Date: 15 September 2021
Our ref: 359645
Your ref: 3/2021/0660

Planning consultation: Bowland Section. From land near the convergence of the Hornby Road, the Roman Road and Shooters Clough to land west of Newton in Bowland; with highway works at various locations from Pimlico Link Road, Clitheroe to Hallgate Hill, Newton in Bowland via Chatburn Road, Ribble Lane, Grindleton Road and Slaidburn Road; a haul route from land south of West Bradford Bridge to West Bradford Road, west of Healings Farm, West Bradford; a vehicle marshalling facility on land at the Ribblesdale Cement Works, West Bradford Road, Clitheroe and a park and ride facility at the existing Ribblesdale Cement Works car park to the west of West Bradford Road. Proposed works for and use of replacement section of aqueduct, including earthworks and ancillary infrastructure including: a new valve house building within fenced compound with permanent vehicular access provision. With the installation of a tunnel portal and an open cut connection area within a temporary construction compound, to include site accesses, storage areas, plant and machinery, and drainage infrastructure and a temporary haul route with bridge over th

SITE LAYOUT
(SCALE 1:2500)

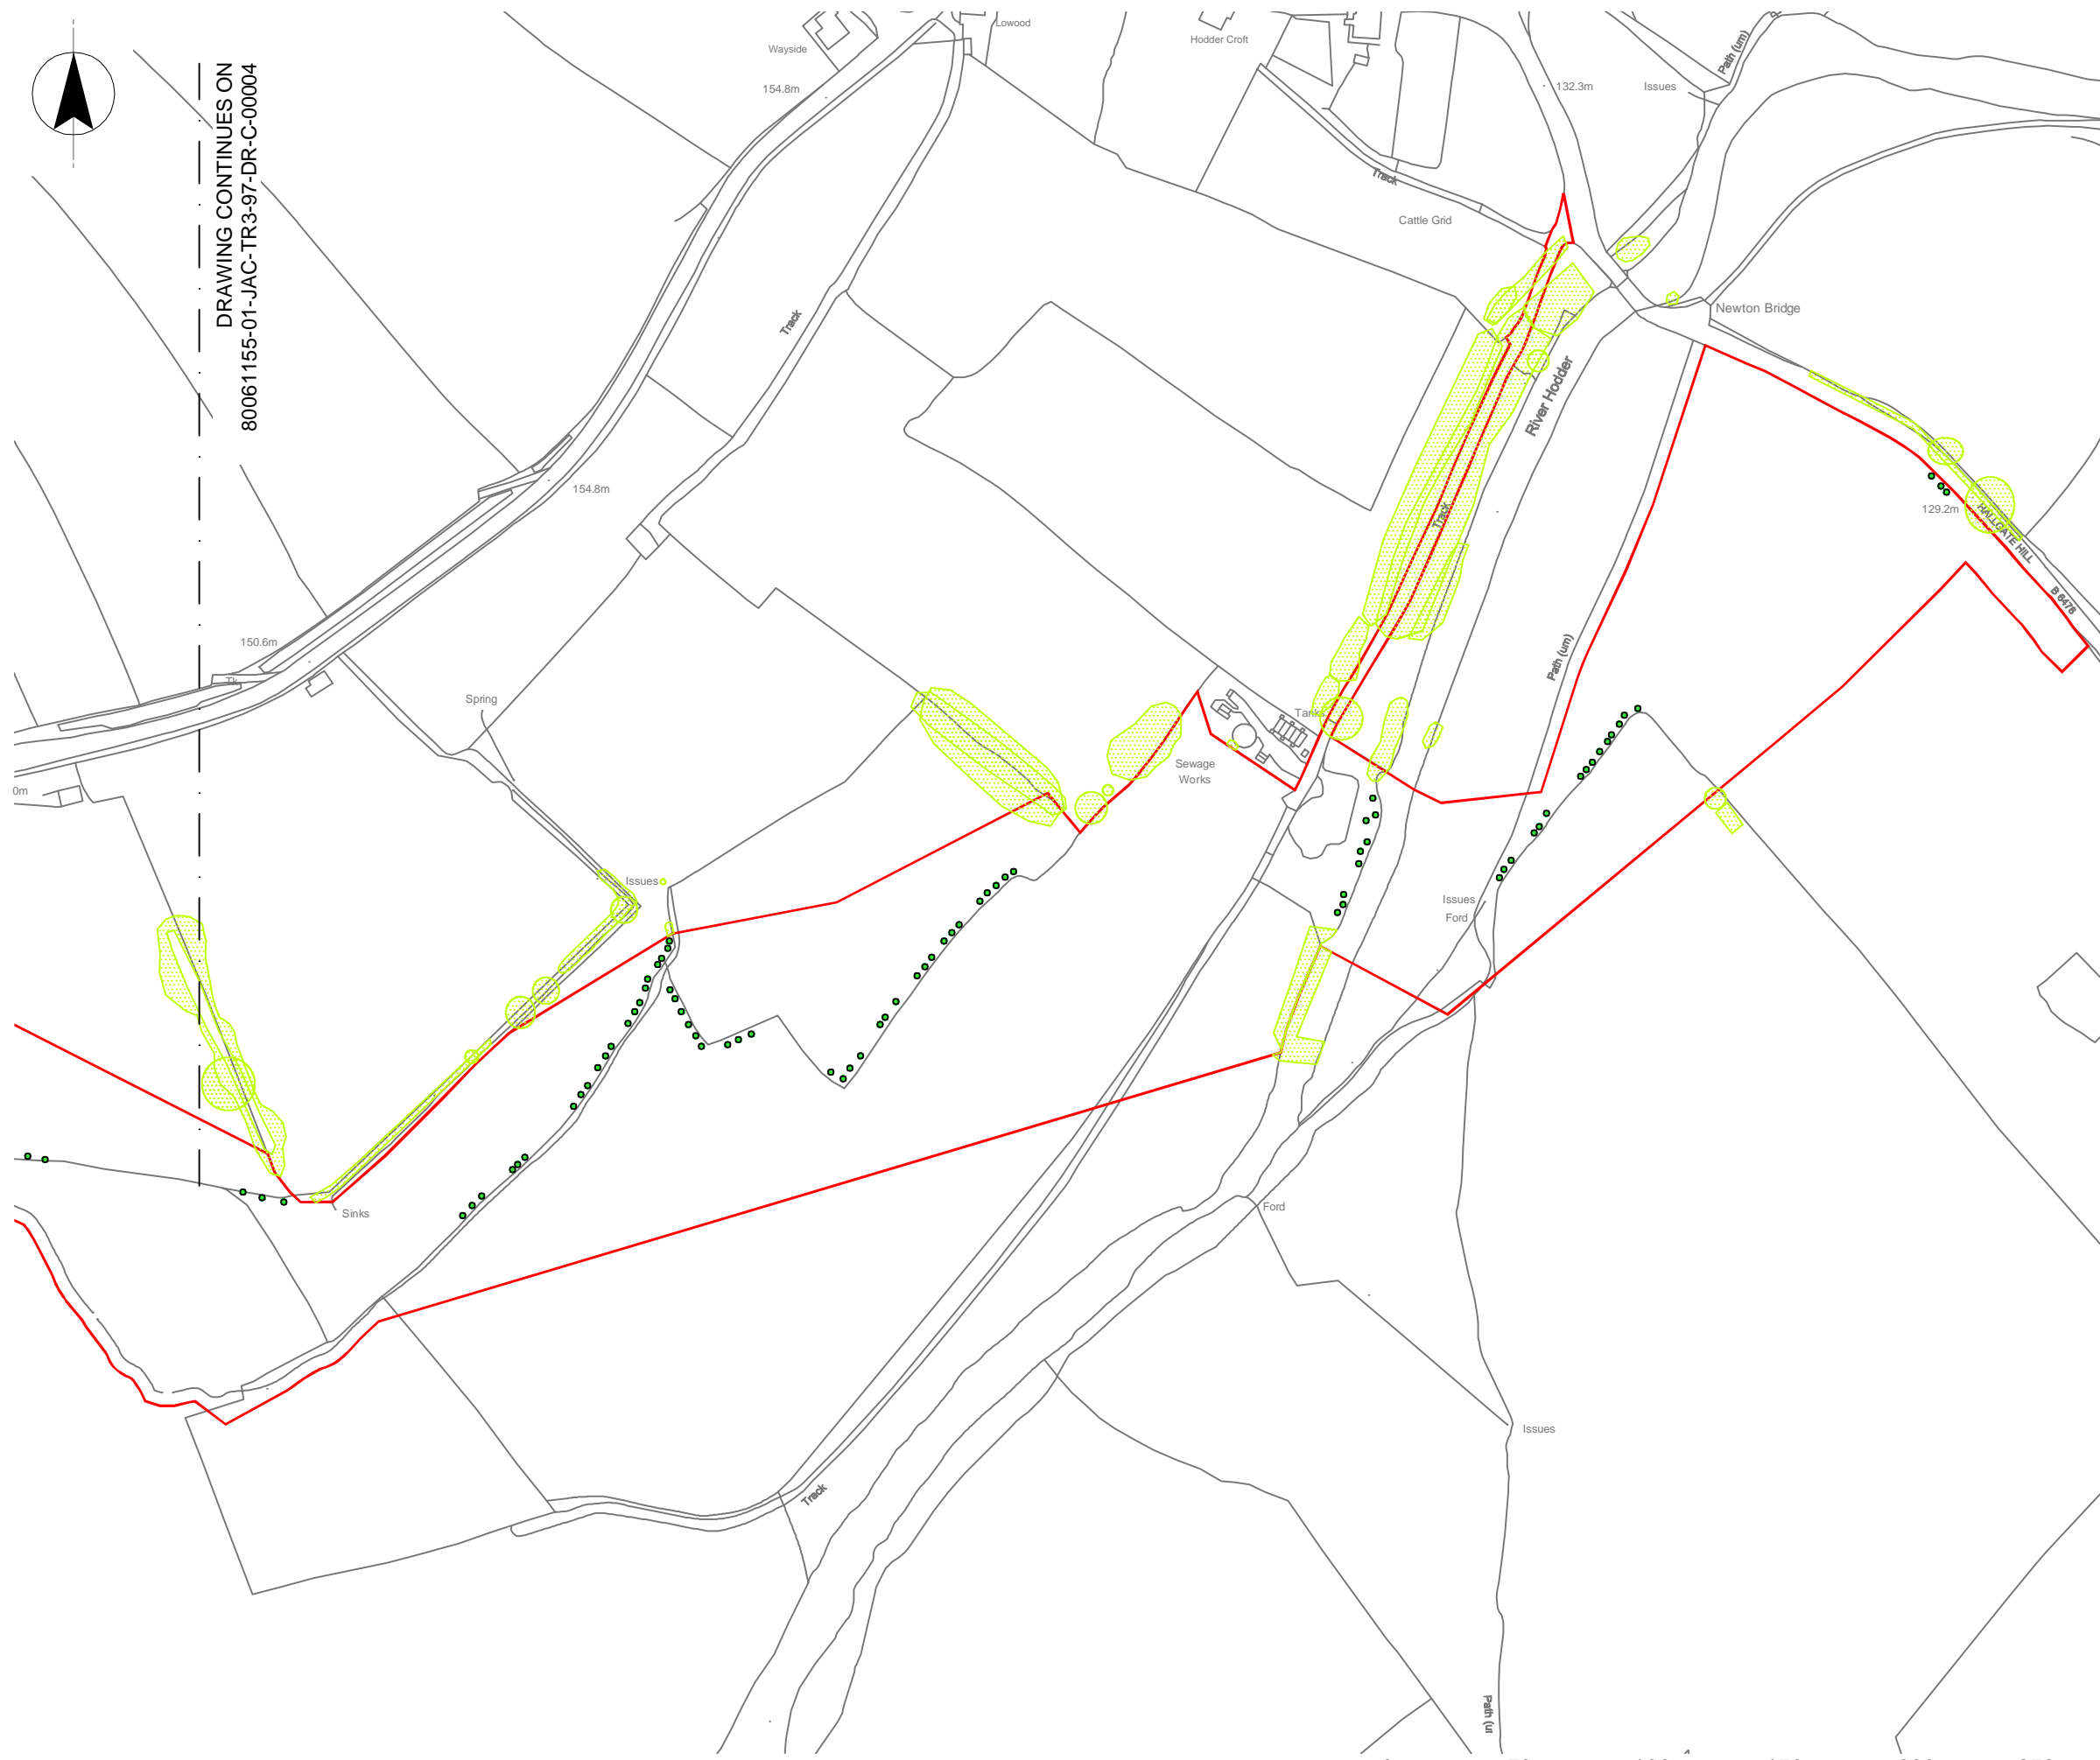
The submitted LVIA (ES Volume 2 Chapter 6) states that enabling, construction and commissioning works for the Newton-in-Bowland compound will '...become the dominant feature in the view and would result in a substantial change to the character of the view. These high sensitivity visual receptors would therefore experience a major magnitude of effect, resulting in a major adverse significance of effect.'

We agree with this assessment. However, what is lacking is a clear explanation of why the compound has to be located as proposed. If there is an overriding reason, presented against NPPF para 177b, for it being within the AONB then a careful search for a site which can best accommodate it should follow. That means searching for a site with the least sensitivity possible, including any existing screening and other mitigation that topography and/or vegetation can provide, together with any potential to enhance that mitigation. The ES chapters are not clear on what, if any, criteria relevant to national planning policy and the statutory purpose of the AONB were used to identify where this compound and other key components of scheme should be located. Were other sites considered and assessed?

We note that no mitigation is proposed for any of the compounds as they are considered to be 'temporary'. We understand that the compounds will be removed and land reinstated once works are complete. In that sense they are 'temporary'. However, the works would be undertaken for a >10 year period which is a long-term presence within the AONB. Mitigation measures should therefore be considered, encompassing both the careful selection of sites and further screening and operational measures. The latter can include lighting and noise reduction strategies.
